RE: 327-355 Burley Road, Horsley Park (SSD-10436) – MOD 4 to Lot 204 (formerly 203) – Request for Additional Information - Transport Statement

Additional Swept Path Assessment and Design Commentary

Figure 6 | Proposed Lot 204 Site Plan (new truck entry/exit point identified in red)

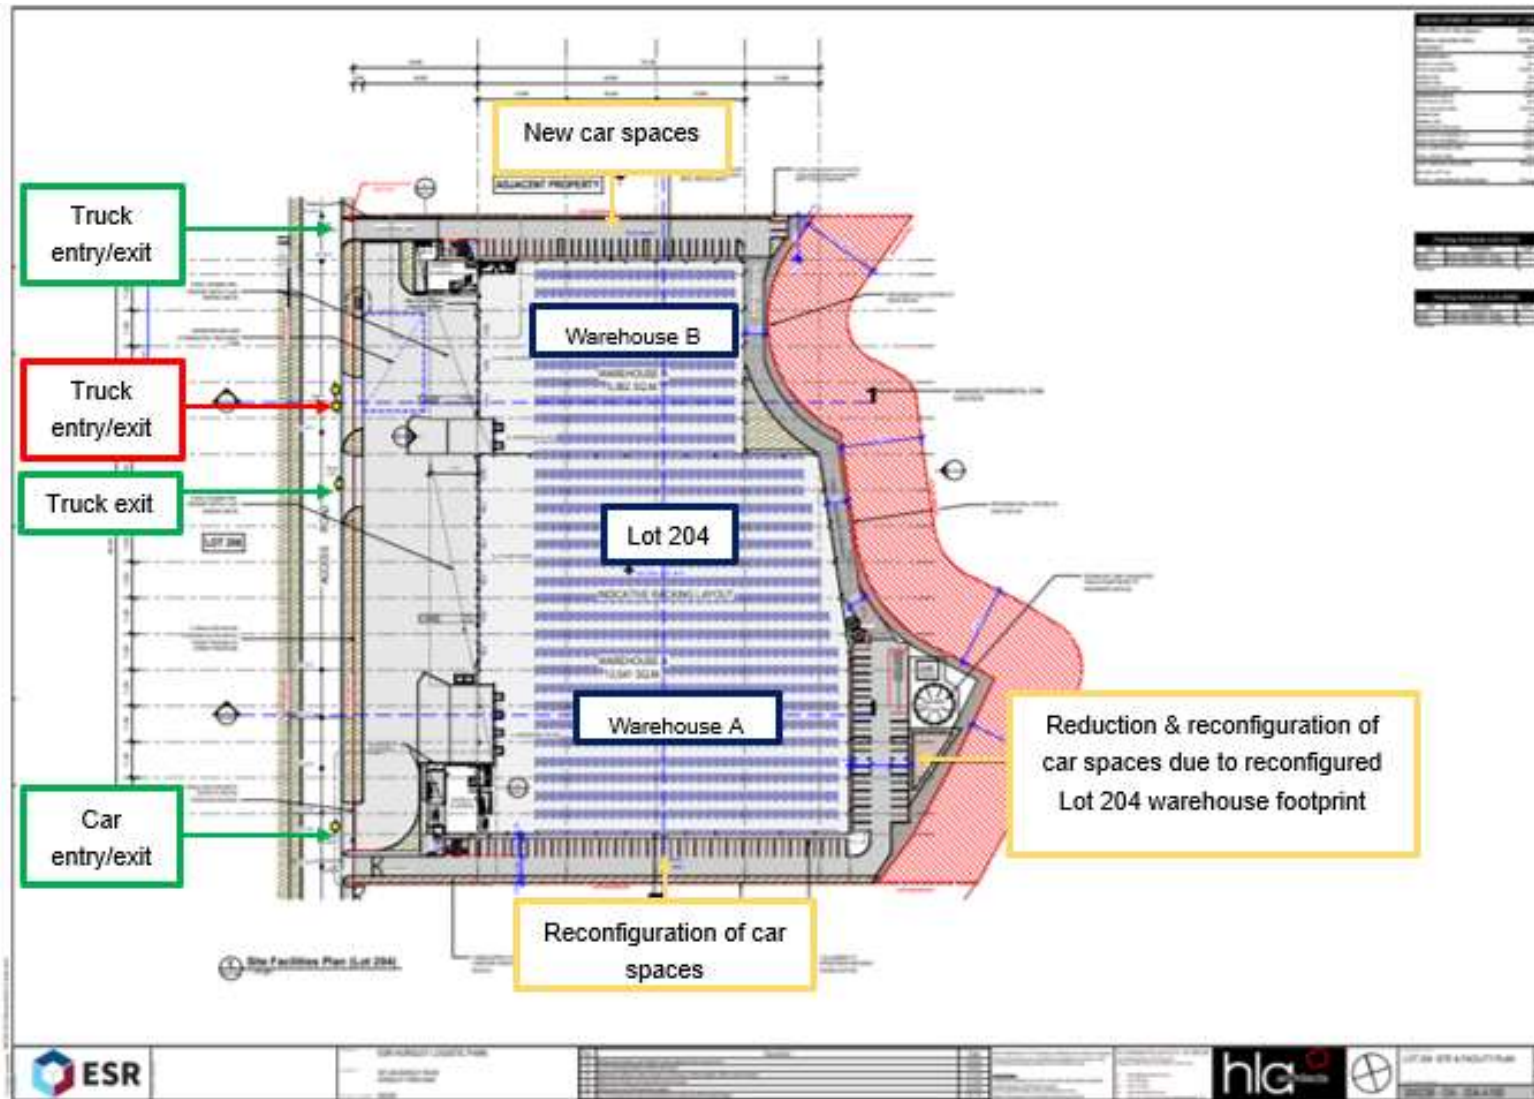
The Department notes the modification includes two truck entries / exits at Lot 204 adjacent to each other on Johnston Crescent. Given Johnston Crescent will carry two-way traffic and connects to Old Wallgrove Road in the future, the Department raises concerns about manoeuvrability and road safety at the proposed truck accesses at Lot 204. Should two 26 m B-Doubles associated with two tenants use the accesses concurrently, there is a potential conflict of movements at the accesses and potential impacts on other road uses travelling north-bound and south-bound on Johnston Crescent. Please clarify the manoeuvrability at the proposed truck accesses including swept path diagrams showing 26 m B-Doubles for both tenancies manoeuvring at the same time and any additional mitigation measures to ensure road safety where applicable.'

'The Department notes the modification includes two truck entries / exits at Lot 204 adjacent to each other on Johnston Crescent. Given Johnston Crescent will carry two-way traffic and connects to Old Wallgrove Road in the future, the Department raises concerns about manoeuvrability and road safety at the proposed truck accesses at Lot 204.'

‘Should two 26 m B-Doubles associated with two tenants use the accesses concurrently, there is a potential conflict of movements at the accesses and potential impacts on other road uses travelling north-bound and south-bound on Johnston Crescent. Please clarify the manoeuvrability at the proposed truck accesses including swept path diagrams showing 26 m B-Doubles for both tenancies manoeuvring at the same time and any additional mitigation measures to ensure road safety where applicable.’

With regards to the truck manoeuvrability at Warehouse A, it is noted that this building provides for a one-way circulation system, with the entry point being located towards the southern boundary of the Site and the exit point being located towards the northern end of Warehouse A. Therefore, there are no conflicts for truck entry and exit at Warehouse A.

Moreover, there are sufficient sight lines at the Warehouse A exit point and at the Warehouse B entry / exit point to ensure when vehicles are entering / exiting from the respective warehouses, drivers will be able to sight oncoming vehicles easily and give-way as required. This ensures minimal road and traffic safety conflicts at the access points along Johnston Crescent.

To formalise this, additional signage and line-marking including a Give-Way sign can be implemented at the Warehouse A exit point to address this comment (and has also been shown within **Attachment A**).

Based on the data provided within **Table 1** and **Table 2** (described in item 1.1), it is highly unlikely that B-doubles will be accessing Warehouses A and B at the same time. Therefore, it can be inferred that the probability of two B-Doubles accessing Warehouses A and B simultaneously and at any given time is close to zero.

Furthermore, it is noted that both Warehouses A and B can accommodate B-doubles. Notwithstanding, although Warehouse B provides for this provision allowing maximum flexibility for the tenant, there will be infrequent B-double movements at this warehouse. This is reiterated within the design assessment (AG1839-03-v03.dwg) which states that when B-doubles are entering / exiting from Warehouse B, there will be no other truck movements within this respective warehouse.

Further to the above reasons, with regards to potential conflicts for vehicles manoeuvring within the Site, tenants can manage heavy vehicle movements within the respective warehouses through a specific management plan. Operational management measures will take place to ensure potential conflicts will be minimised as much as practically possible.

Figure 8 | Swept path diagram AG11 – 12.5 m HRV emergency vehicle

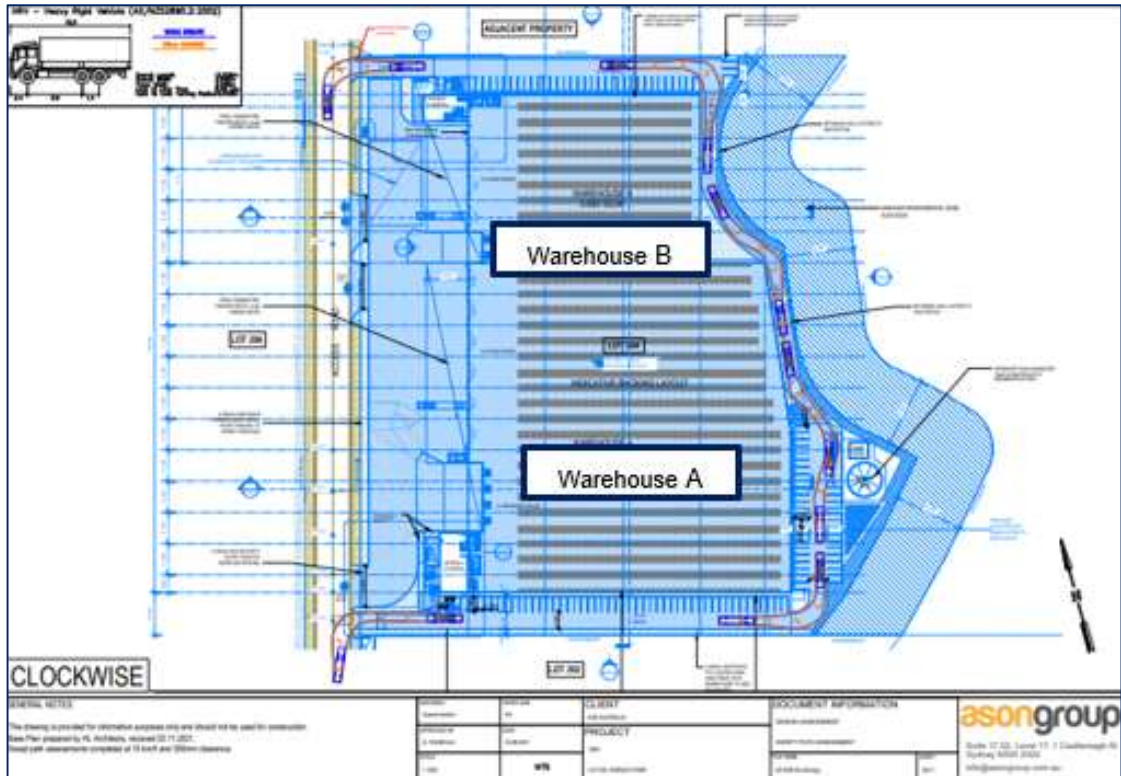
‘Swept path diagram (file name AG1839-03-v03.dwg sheet AG11) shows that heavy rigid vehicles entering the southernmost and northernmost driveways of the site will potentially conflict with other road users. The width of the driveways is not sufficient to cater for the simultaneous movements of a HRV and another vehicle. Additional information shall be submitted to Council to address this concern; and’

It is noted that the 12.5m Heavy Rigid Vehicle (HRV) represent fire trucks entering the car park from the northernmost driveway and exiting from the southernmost driveway will only do so during an emergency event and on a very rare occasion. This swept path has been shown to confirm that during such emergency events, fire trucks can access the proposed development with no issues. Otherwise, these driveways will only be utilised by light vehicles on a regular basis.

It is also important to consider that light vehicles are unlikely to try to enter nor exit the Site during this event. Therefore, there is little possibility for potential conflicts at the northernmost and southernmost car park access driveways (as this event only happens during an emergency and is not a regular occurrence).
